# A417 Missing Link DCO

Joint Councils Deadline 5 submission

9 March 2022

Document title: Joint Councils Deadline 5 submission

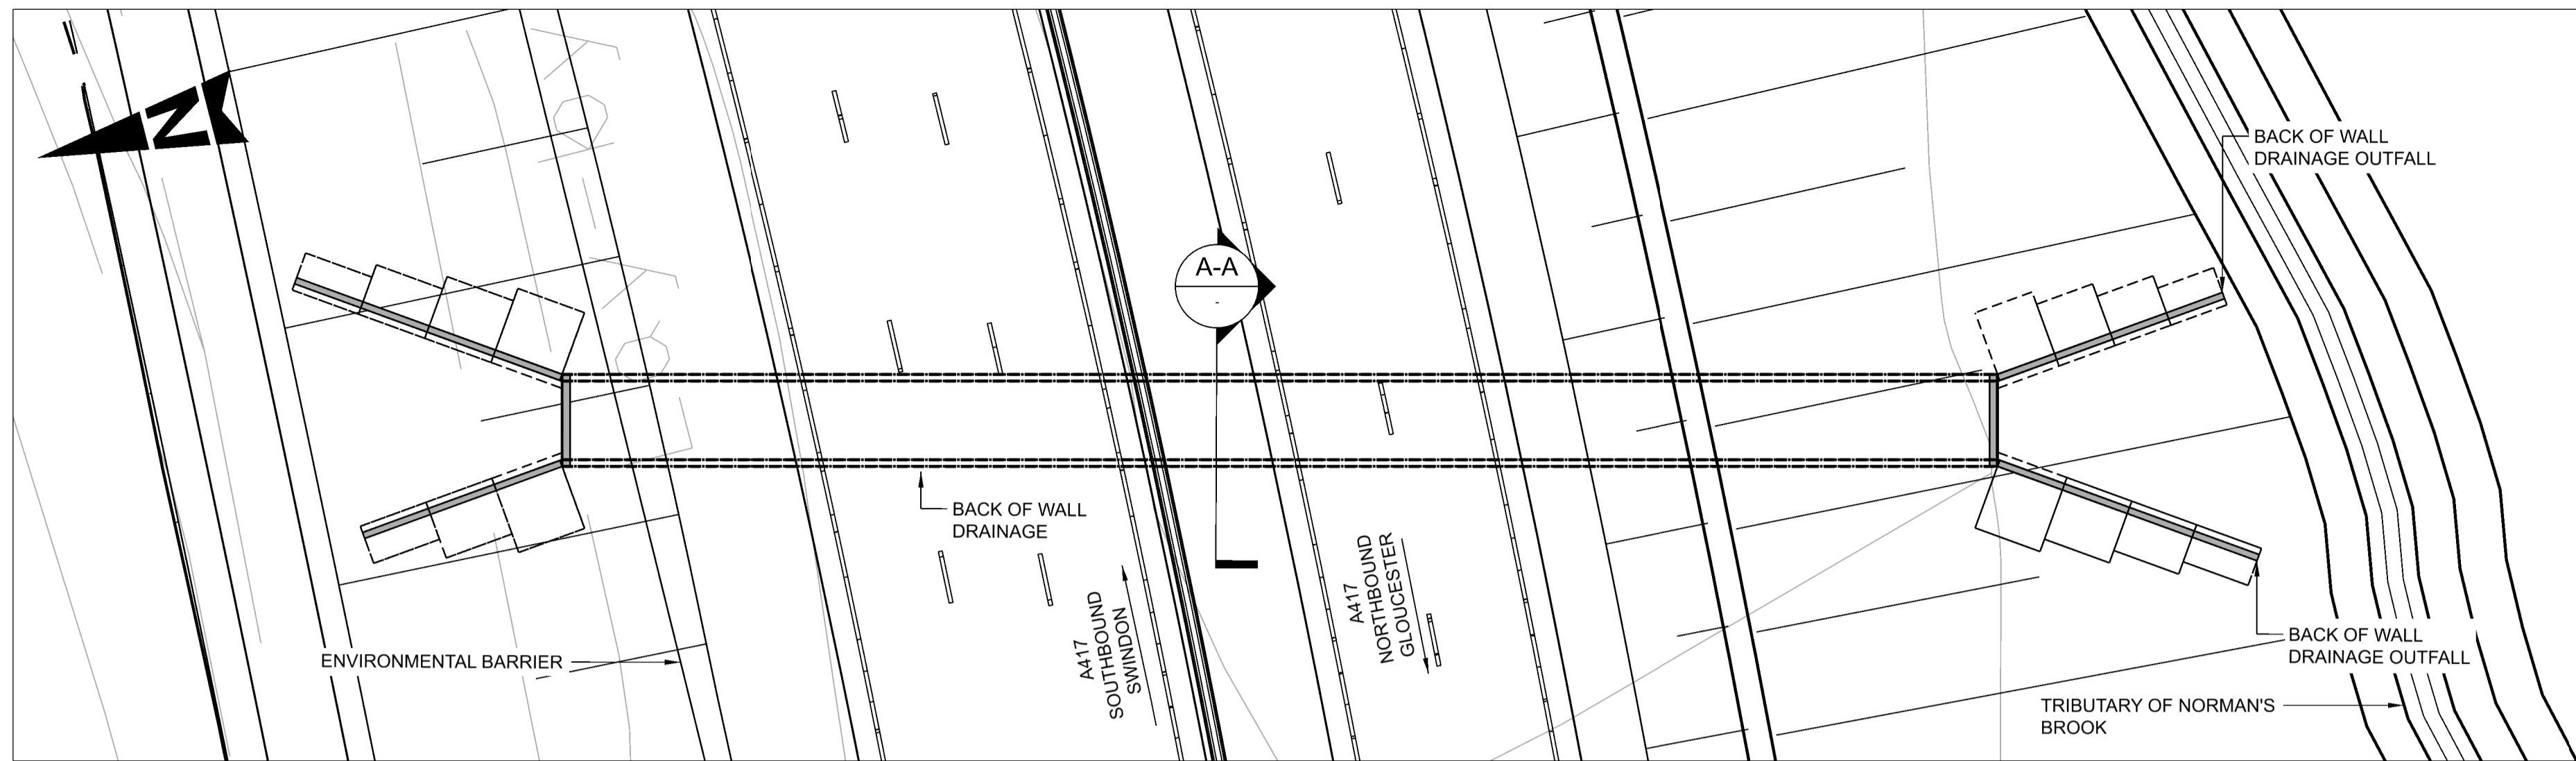
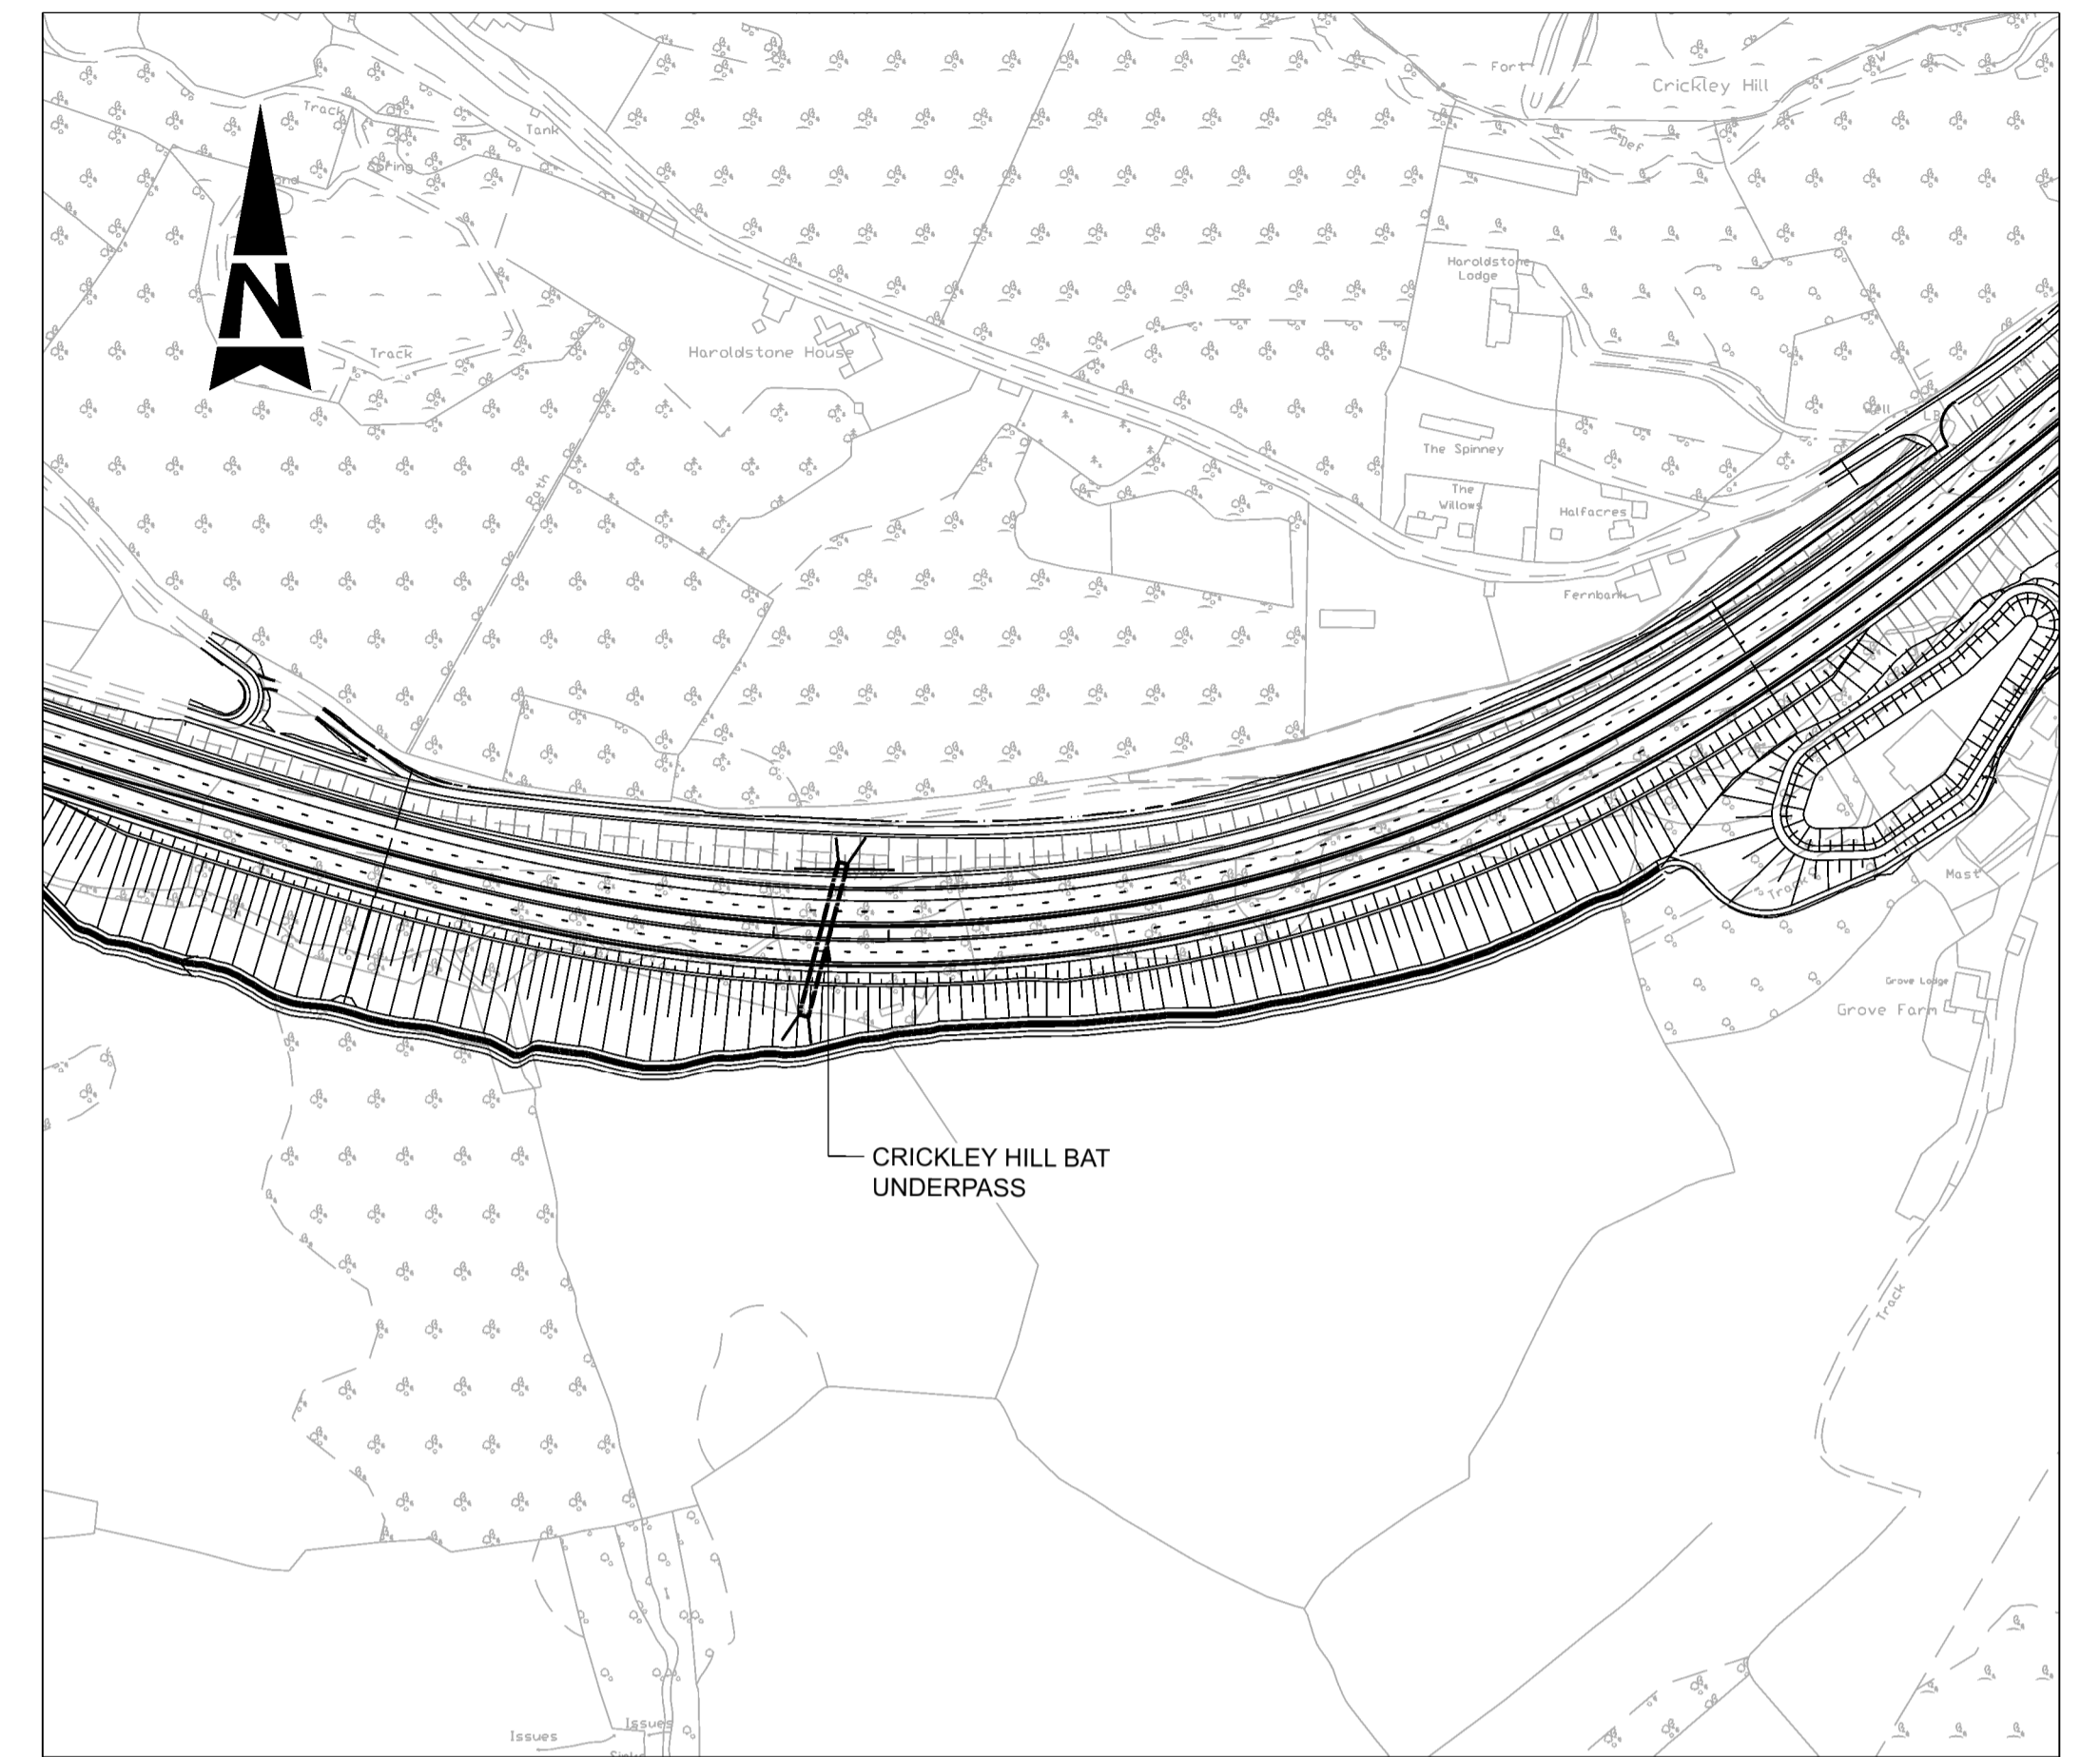
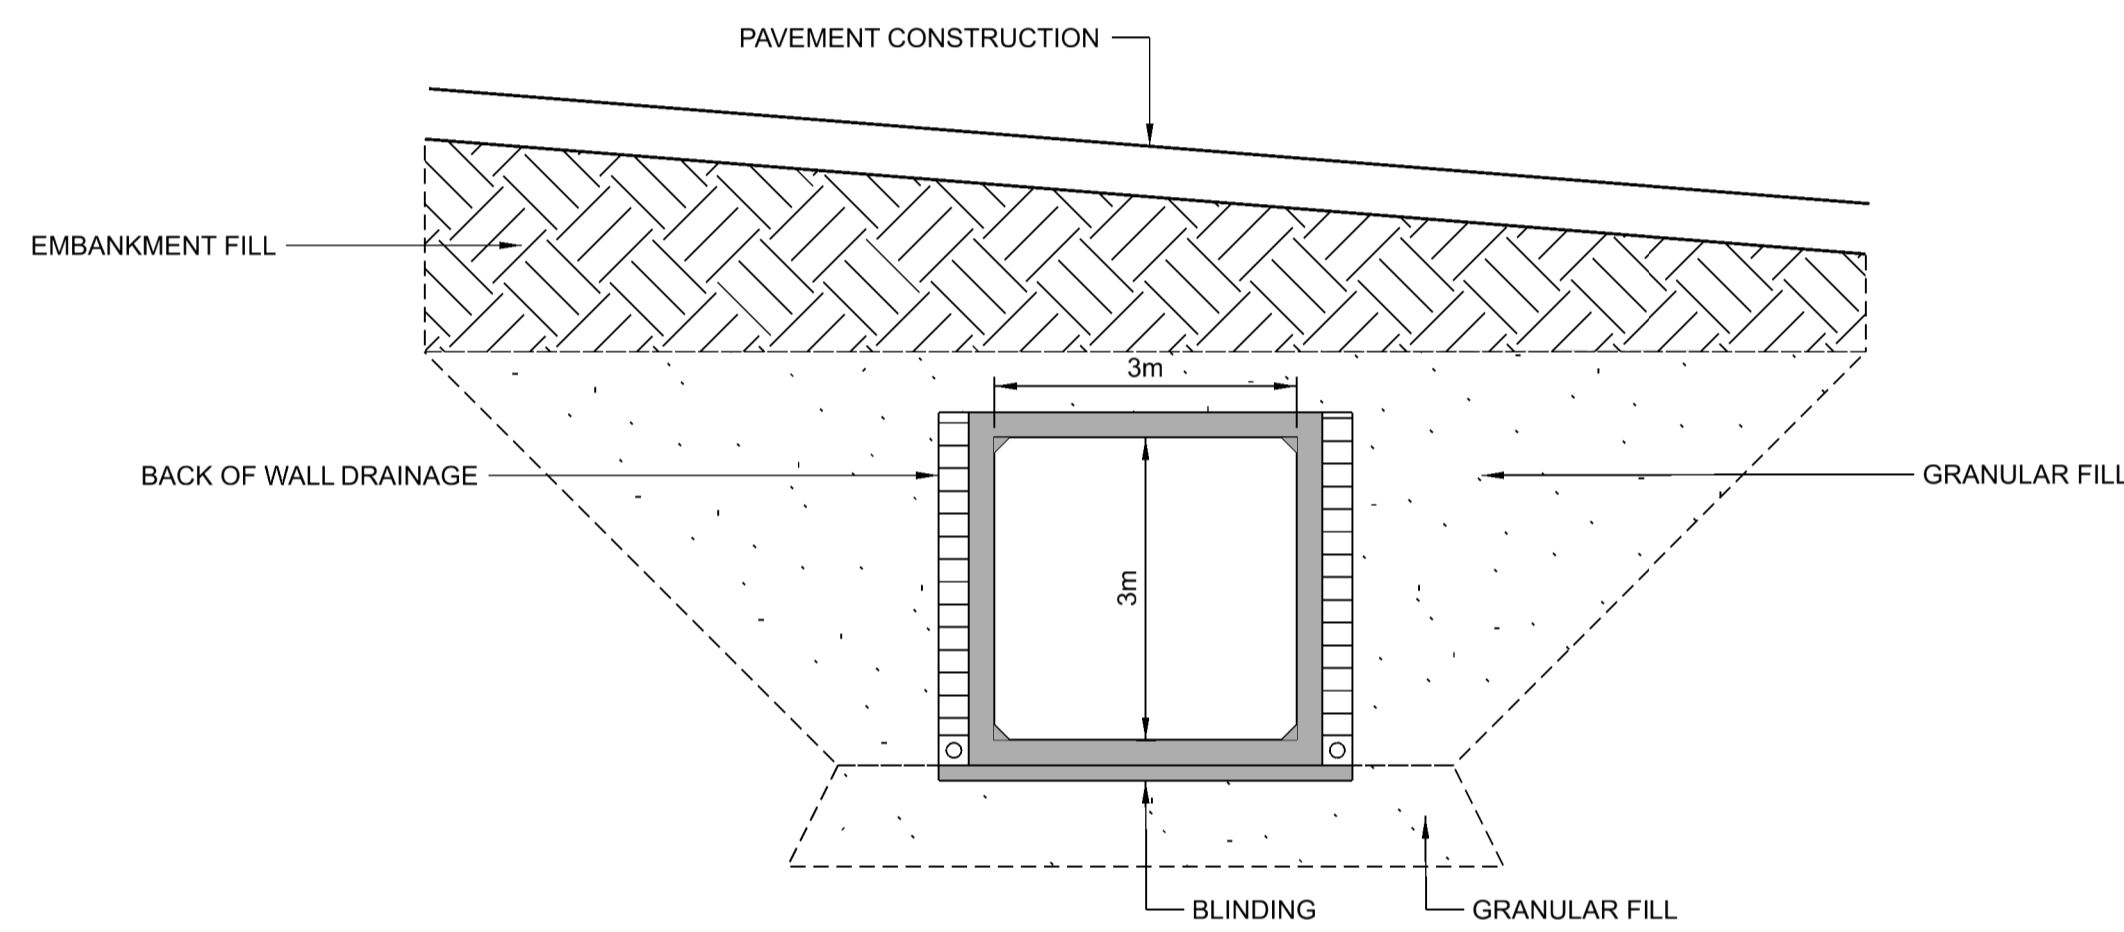
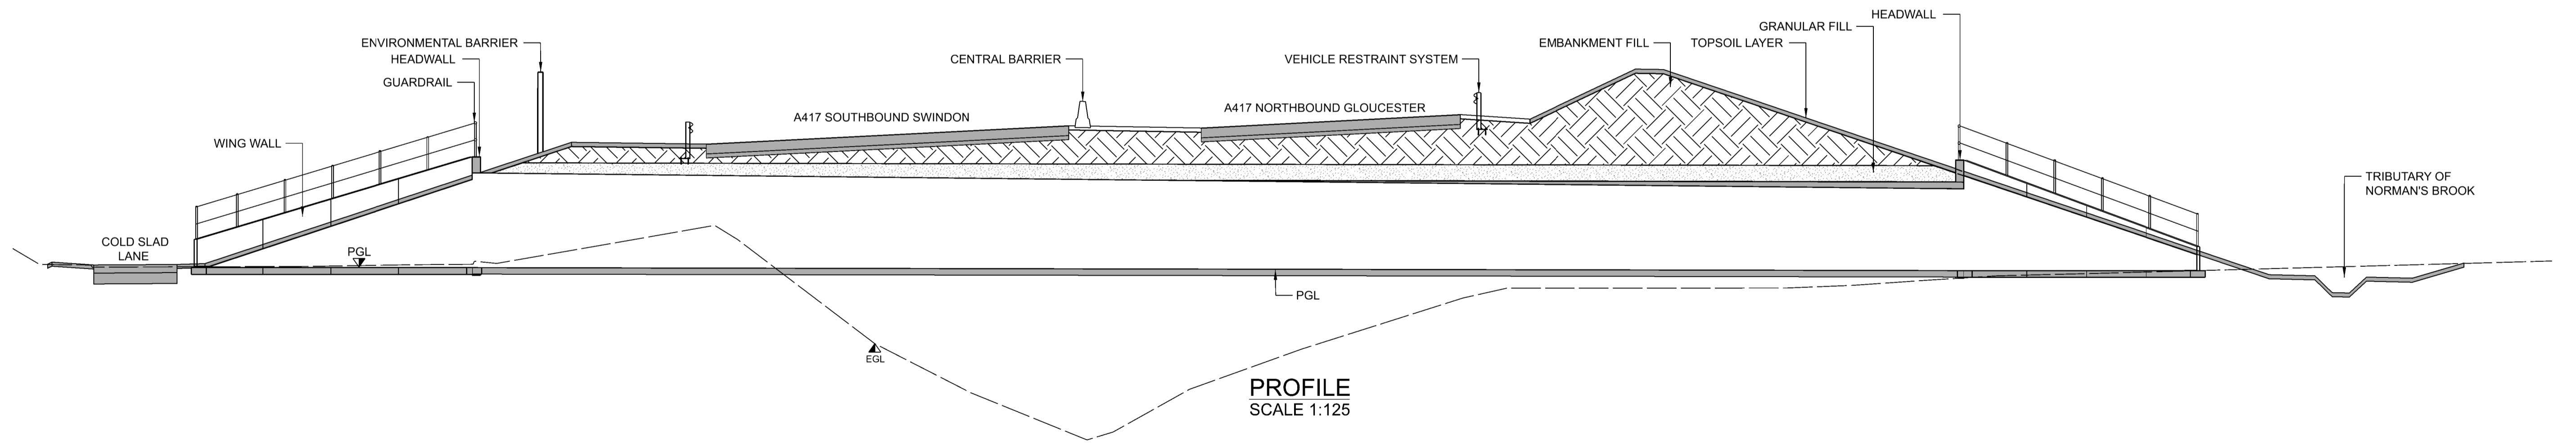
- There should be clear evidence that the suite of bridges – Gloucestershire Way bridge, Stockwell bridge and Cowley bridge will provide both human and wildlife connectivity. We are still concerned that these structures will not provide the necessary landscape connectivity nor be engineered to sustain habitats (whether hedgerows and trees on Stockwell and Cowley, or full habitat creation on Gloucestershire Way bridge).
